PROJECT NO. PR-2020-004820

Application No. SI-2020-001468

Memorandum

Re: Hotel Circle Ramada Apartment Conversion DRB Comment Responses (PR-2020-004820)

SHEET TITLE
SITE UTILITY PLAN
 SHEET NUMBER
CU-101

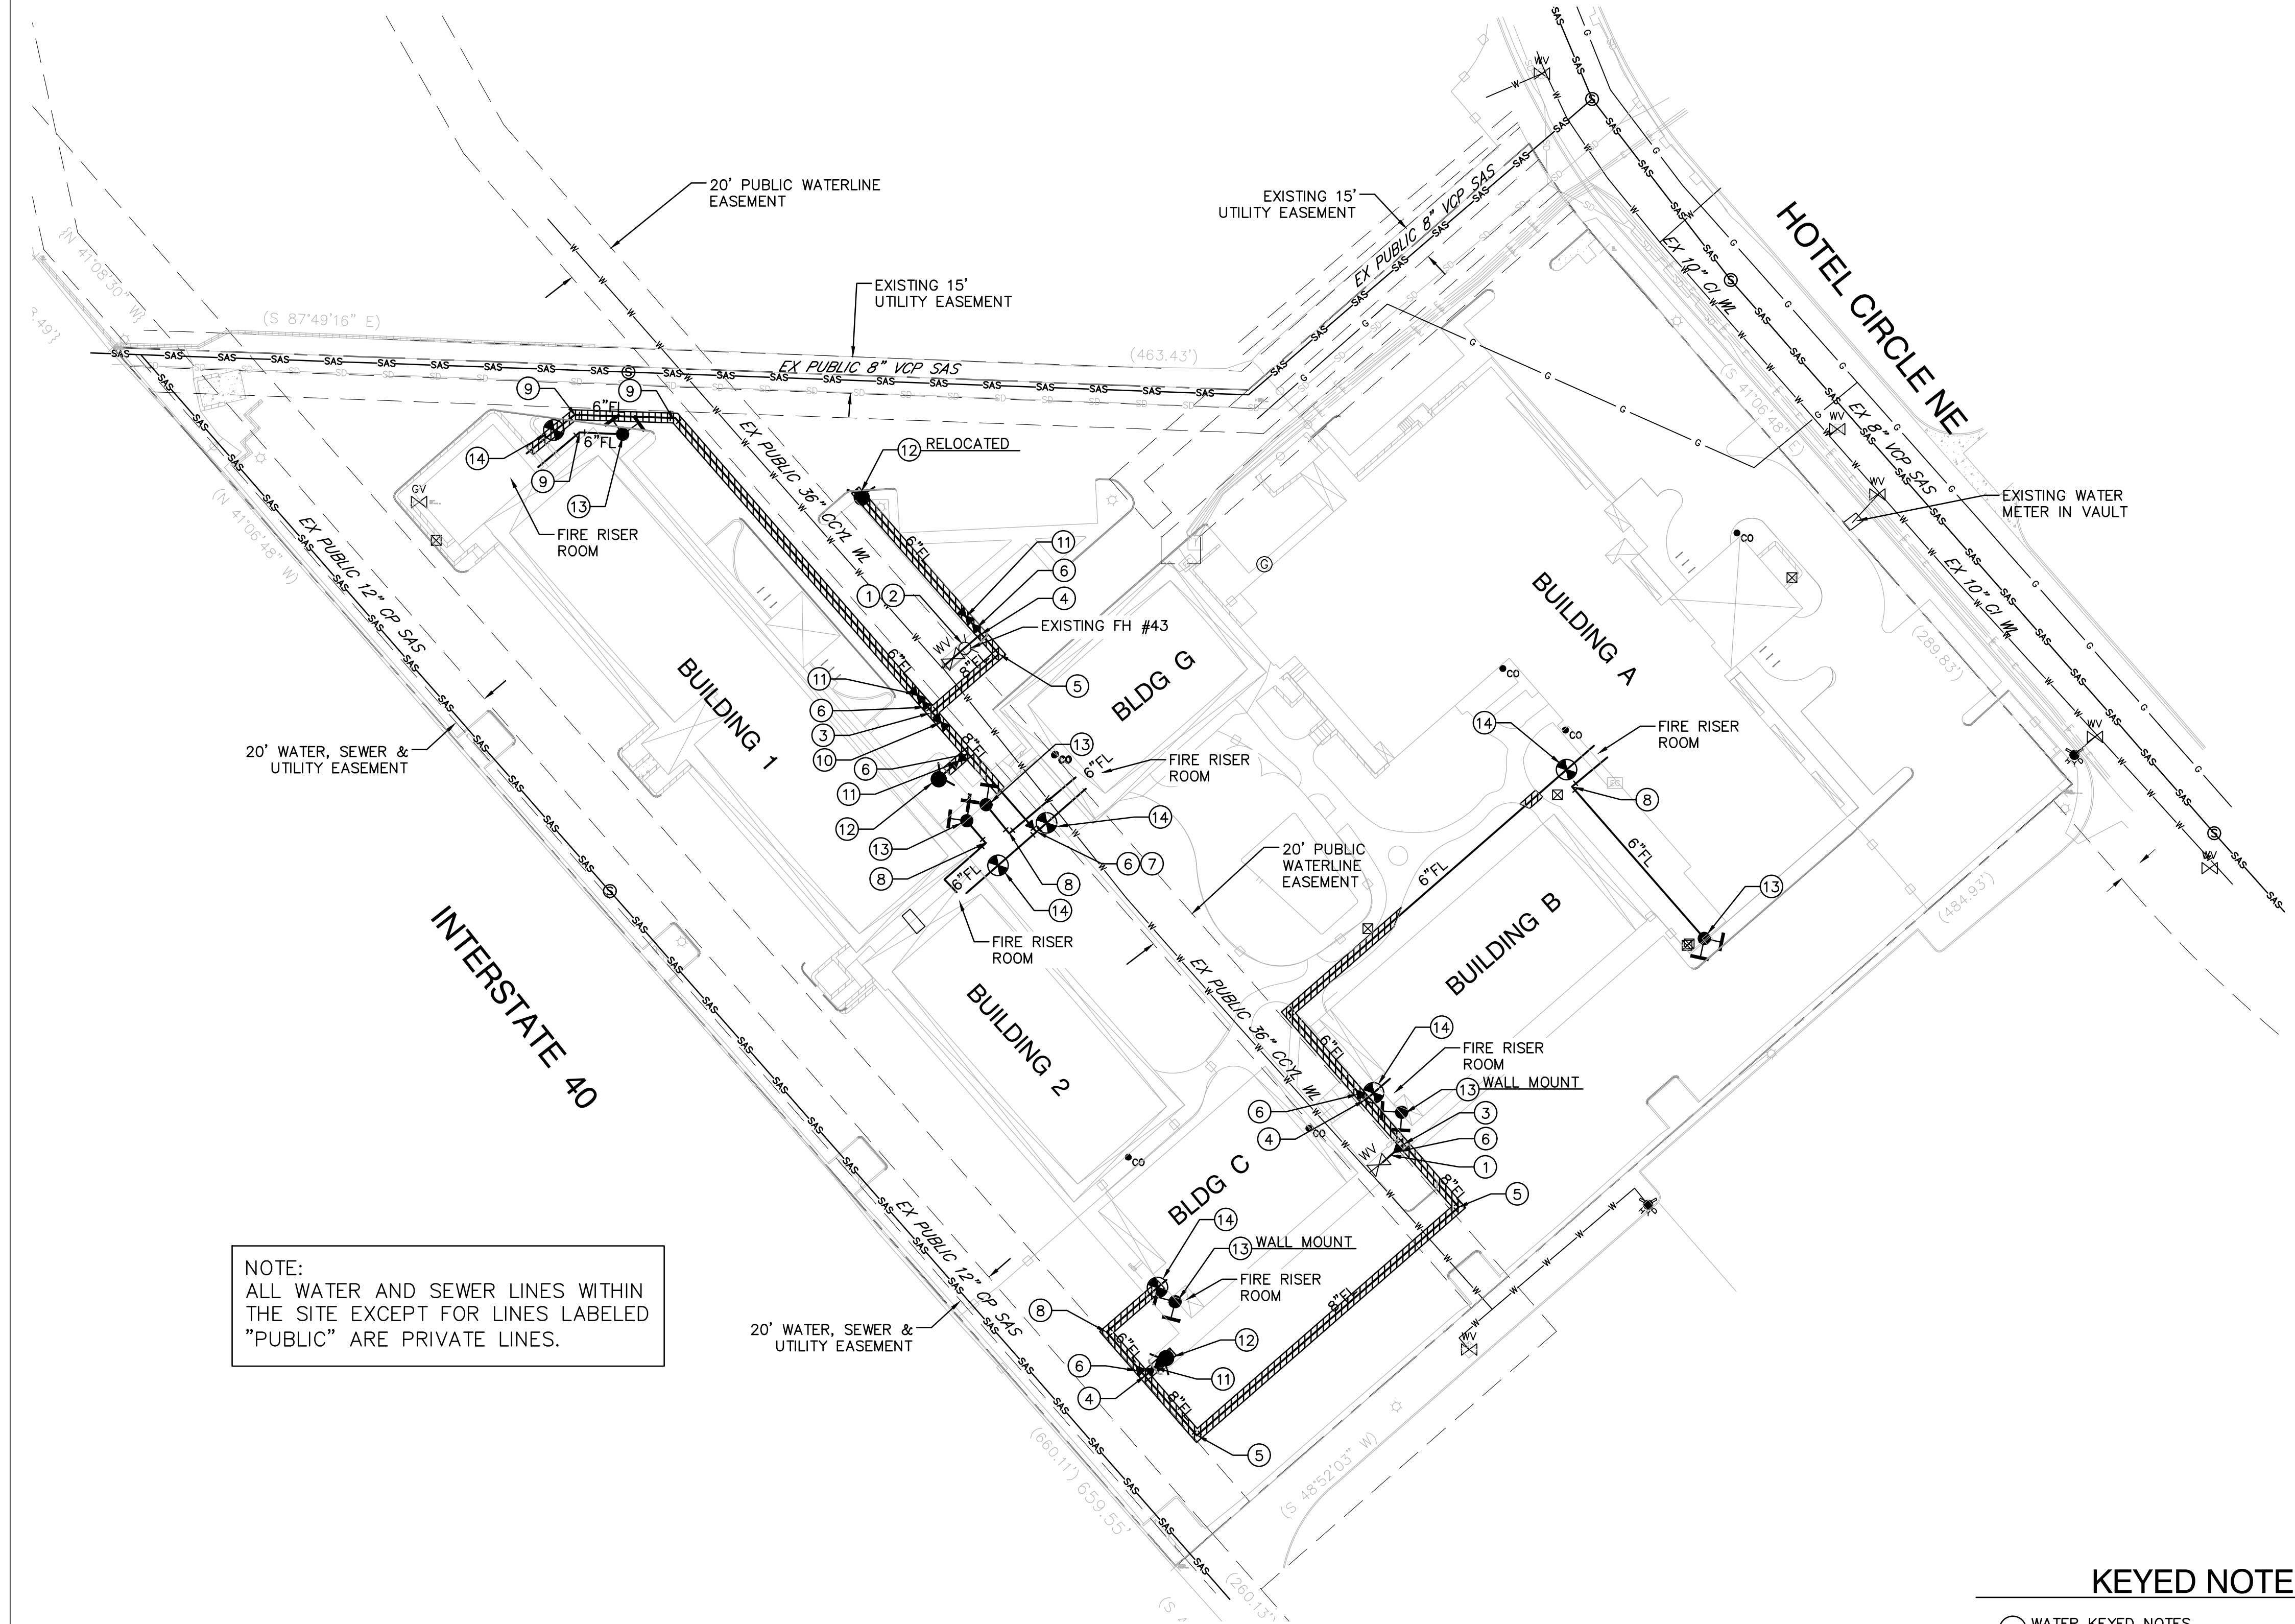
PREVIOUS COMMENT: Please show existing onsite public waterline and sanitary sewer. The utility plan does not show the existing sanitary sewer along the western property line.

The meter to be used is not shown.

Label buildings.

- a. *The plans have been updated accordingly.***

**AS103**

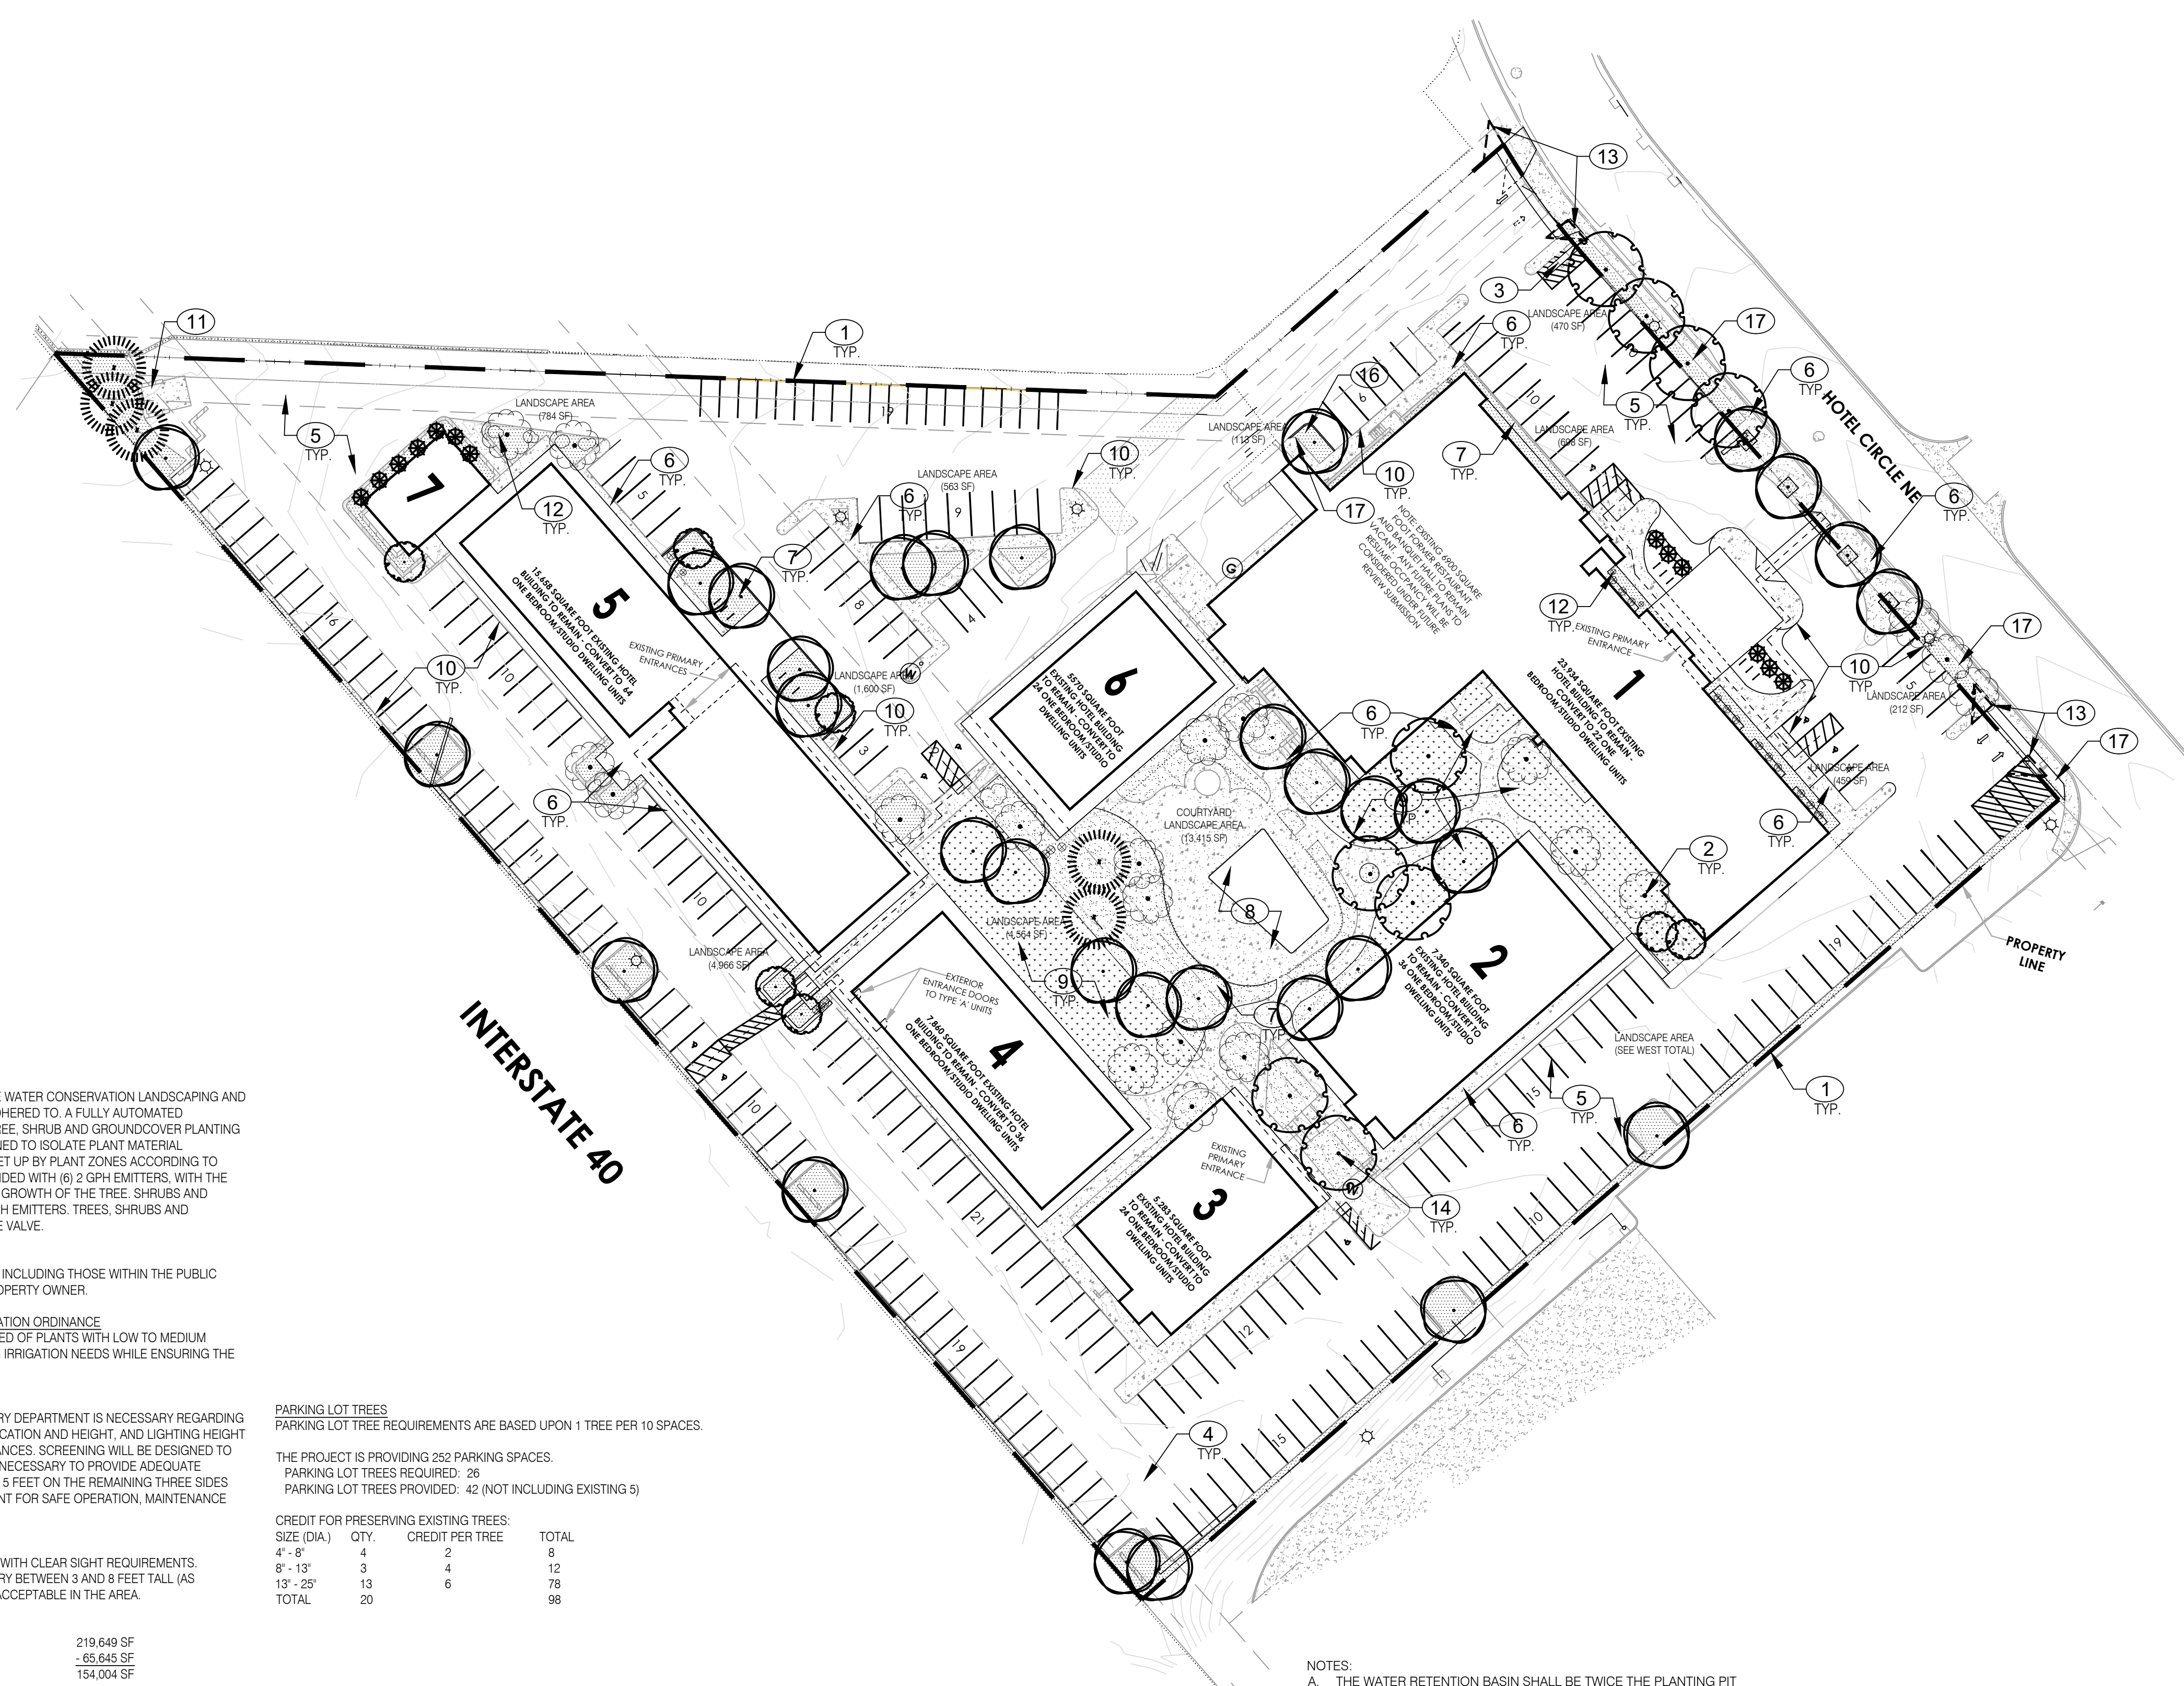
4. The driveways shall have a 4-foot ADA pathway. Provide details to show connectivity.
 - a. **The driveways have been updated to show a 4-foot pathway. A new detail showing this condition has been added on Sheet AS103.**

7. On the detail for the handicapped ramp that is perpendicular to the parking lot, show a minimum 4-foot pathway at the top of the ramp for turning a wheelchair.

- a. **This detail has been updated.**
8. Dimension all van accessible aisles and other handicapped aisles.
 - a. **Additional dimensioning has been added.**
